**SECTION 75W MODIFICATION TO APPROVED SERVICED APARTMENTS– MP 08\_0155  
SITE 22 - EDWIN FLACK AVENUE, SYDNEY OLYMPIC PARK**

On behalf of SOPPROP Pty Ltd, we write to request the Minister (or his delegate) modify the Project Approval 08-0155 under Section 75W of the *Environmental Planning and Assessment Act 1979* as described below. The proposed modifications generally involve changes to the approved building materials and finishes, modifications to the western elevation including the introduction of balconies and windows within this elevation, the introduction of windows within the southern elevation and reconfiguration of ground level retail tenancies and access.

Basement 1

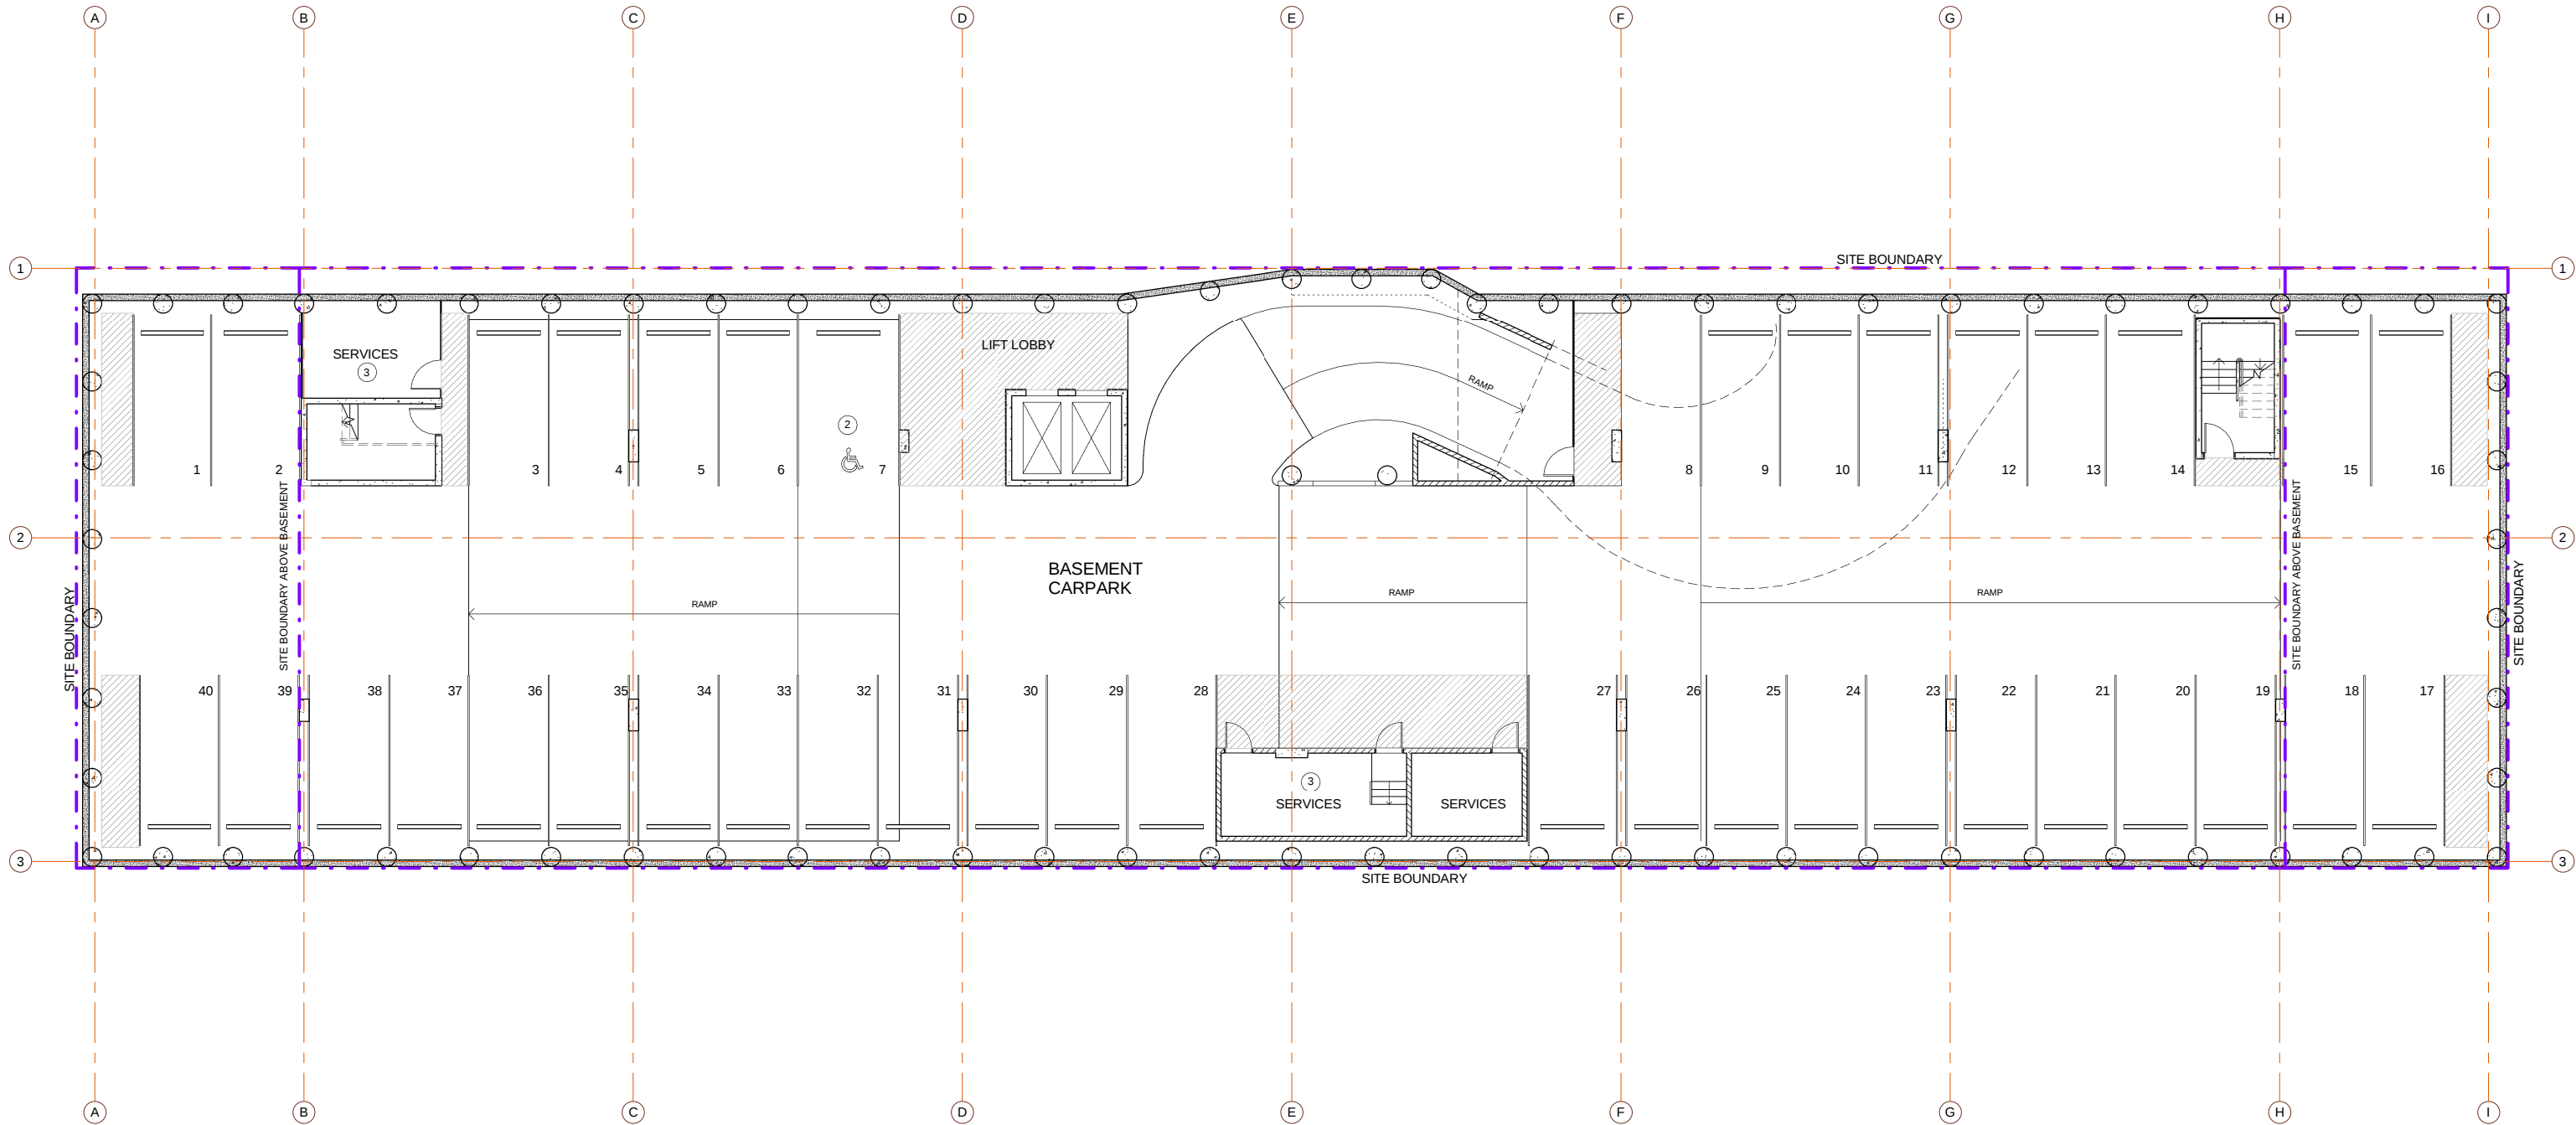
Floor / Elevation	Modification	Justification
Location / Site Plan (Drawing 01, Issue D dated 25 November 2010)	No change	No change
Basement (Drawing 03, Issue D dated 25 November 2010)	The access ramp to the car park has been modified	The amendment has been made to comply with AS 2890
	The layout of the car park has been reconfigured	The layout of the car park has been modified to accommodate other changes that needed to be made to comply with Australian Standards.
	The disabled car space has been moved closer to lift	The amendment has been made to comply with AS 2890.
	Plant rooms have been introduced	This change has been implemented to reduce the transfer of services across the roof to a minimum.
Ground Level (Drawing 04, Issue D dated 25 November 2010)	Parking at the rear of the building has been reduced from 4 to 3 spaces	Design development and requirement to provide modified access to basement level car park.

1 Ground Floor
04 1 : 100

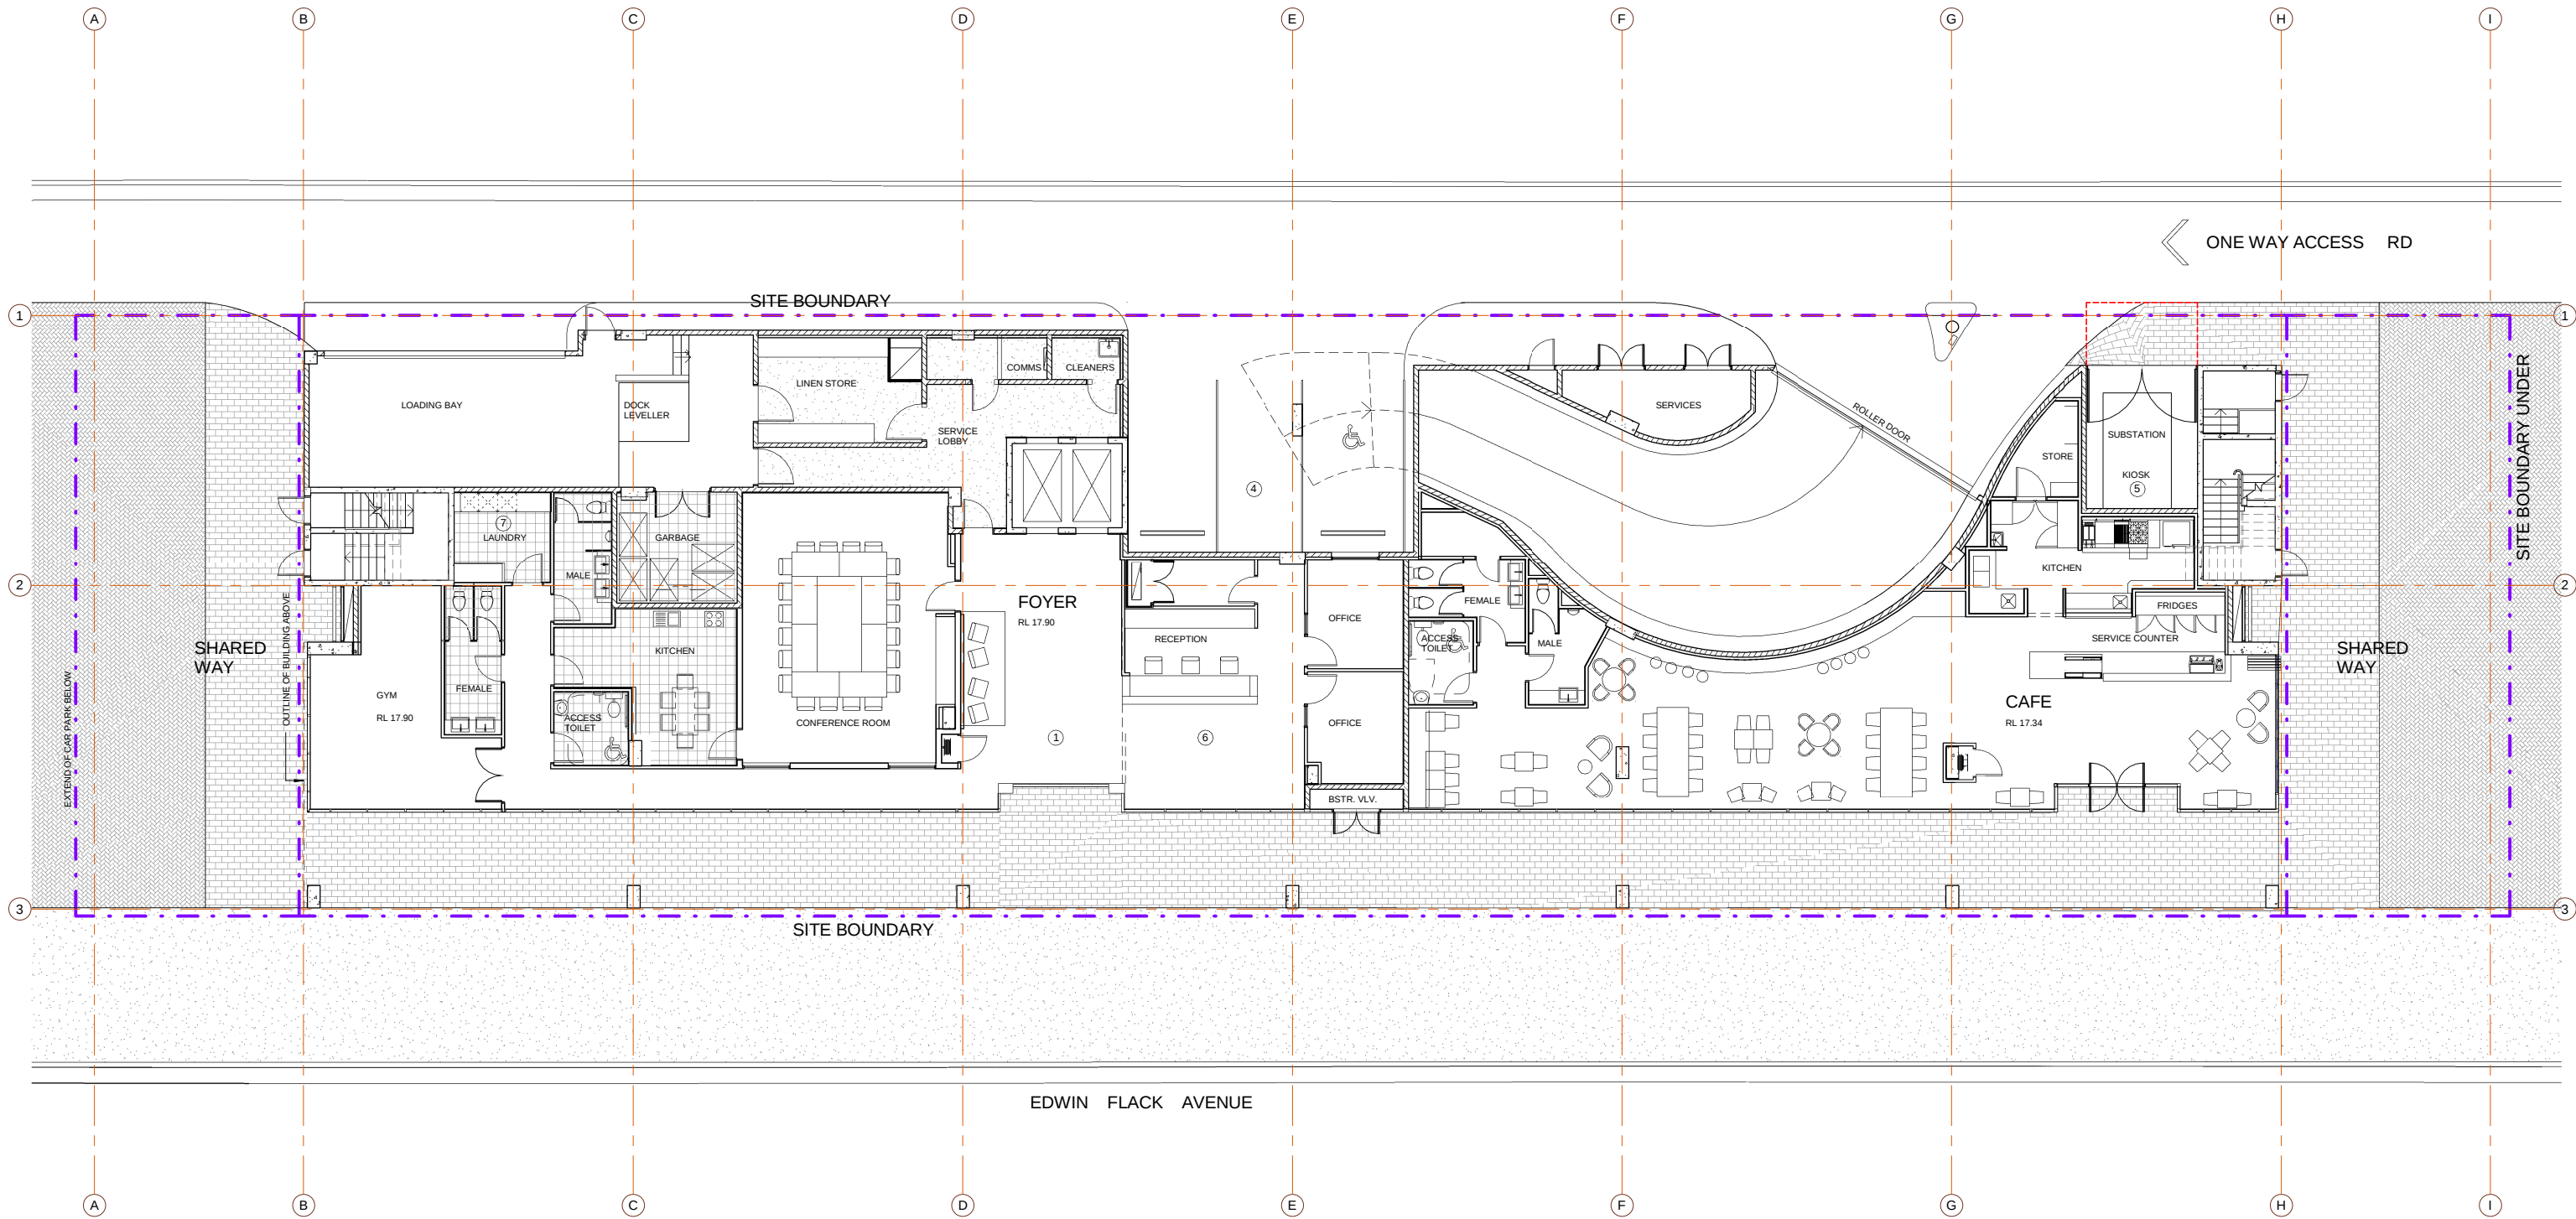
Relocation of substation further to the North	The substation has been relocated to suit the needs of Energy Australia
	Reconfiguration of reception area	Reception / foyer area reconfigured and increased in size to improve functionality of this area and access to it
	A common laundry has been included	The inclusion of a common laundry will

Floor / Elevation	Modification	Justification
		increase the amenity for users through the provision of an additional facility
	The male and female gym showers have been removed	The use of the gym is for guests only. Staff members will have access to showers in other parts of the building if required; hence shower facilities are not necessary.
	The three retail tenancies have been combined into a single cafe tenancy with associated bathroom facilities	Requirement of café tenant. The retail GFA has increased by 31m <sup>2</sup> , however the buildings overall GFA remains unchanged.
Levels 1-7 (Drawings 05 to DA011, Issue D dated 25 November 2010)	A disabled access room has been provided on each floor	The provision of seven rooms that are suitable for disabled persons increases the equitability of access to the development
	Minor alterations have been made to the layout in some apartments (e.g. positioning of wardrobes)	Detailed design changes to accommodate provision of services. The overall apartment mix, number of rooms remains unchanged

1 West Elevation
A 0005 1 : 100

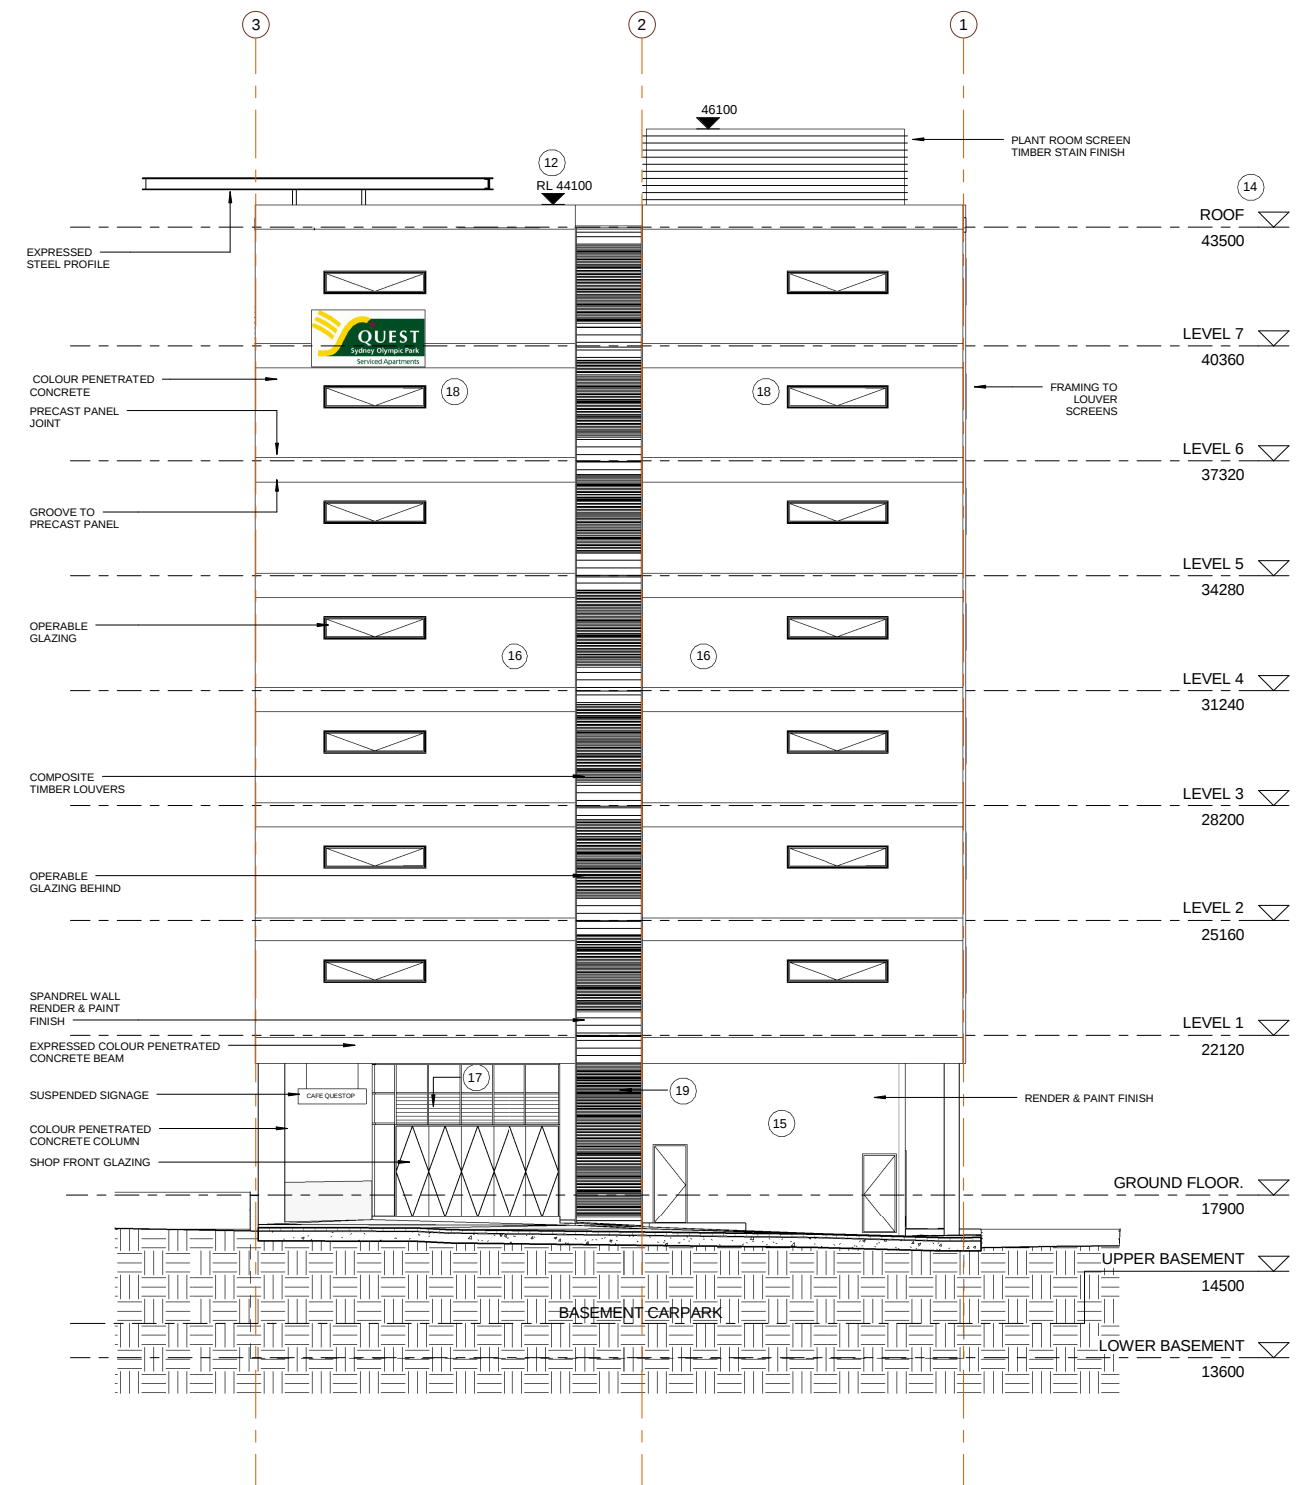
Western Elevation (Drawing 13, Issue D dated 25 November 2010)	The en-suite windows have been deleted	The en-suite windows have been deleted to achieve a superior design outcome following the removal of the louvers. The removal of the en-suite windows is not deemed to have any negative impacts upon amenity and will increase privacy for building guests
	Balconies have been introduced	The additional balconies increase the amenity of the apartments and increase the amount of natural light. Solid and glass balustrades have been provided to provide variety in the design. The colour scheme has been extended to reduce glare and to limit reflectivity to a maximum of 20%
	Louvers have been removed	Louvers have been removed to increase the amount of natural light to western facing apartments, shading is still provided by the slabs above the balconies

Floor / Elevation	Modification	Justification
	Double glazed windows have been introduced	This change has been introduced throughout the project to reduce the solar heat load in order to achieve an overall low energy demand equivalent to a 4 star Green Star rating
Western Elevation Ground Floor (Drawing 13, Issue D dated 25 November 2010)	The composite timber cladding has been changed to render and paint	The material change on the ground floor is limited to the rear of the building that does not face on to pedestrian areas. The major pedestrian pathways at ground level are on Edwin Flack Avenue where no substitution of materials has been made. The extent of material substitution is considered to be acceptable and more efficient allocation of resources given the intended use of the rear lane (deliveries, service vehicles etc)
	The concrete finish has been changed from honed to colour penetrated concrete	The honed finish cannot be applied to all surfaces of the precast elements. A high quality substitute material has been chosen, with a similar physical appearance that will allow a uniform look. The colour scheme provides variety in the design and reduces glare by limiting the reflectivity to a maximum of 20%

The proposed changes to the western elevation including introduction of balconies off bedroom and living areas and changes to the approved materials and finishes are proposed to further improve the appearance of the building from the public domain, in particular the rear lane, and to improve building occupant's amenity. The proposed changes are also required as a result of further detailed design and will not result in the diminution of the design quality of the building. A sample board of the revised facade materials has been provided as part of this application.

The removal of the louvers is facilitated through the introduction of double glazed windows. Double glazing has the advantage of reducing the solar heat load, enabling the development to achieve a 4 star Green Star rating, while providing building guests with increased amenity through solar access and allowing balconies to be capable of receiving full sun if desired. Shading remains in place, provided by the slabs above the balconies.

Information Paper 5: IEQ-5 Thermal Comfort Results (**Attachment F**) demonstrates that using performance double glazing (U-value 3.5, SHGC 0.3) as proposed for all external glazing will ensure the weighted average heating and cooling loads across all apartments will be less than 30 MJ/m<sup>2</sup>.
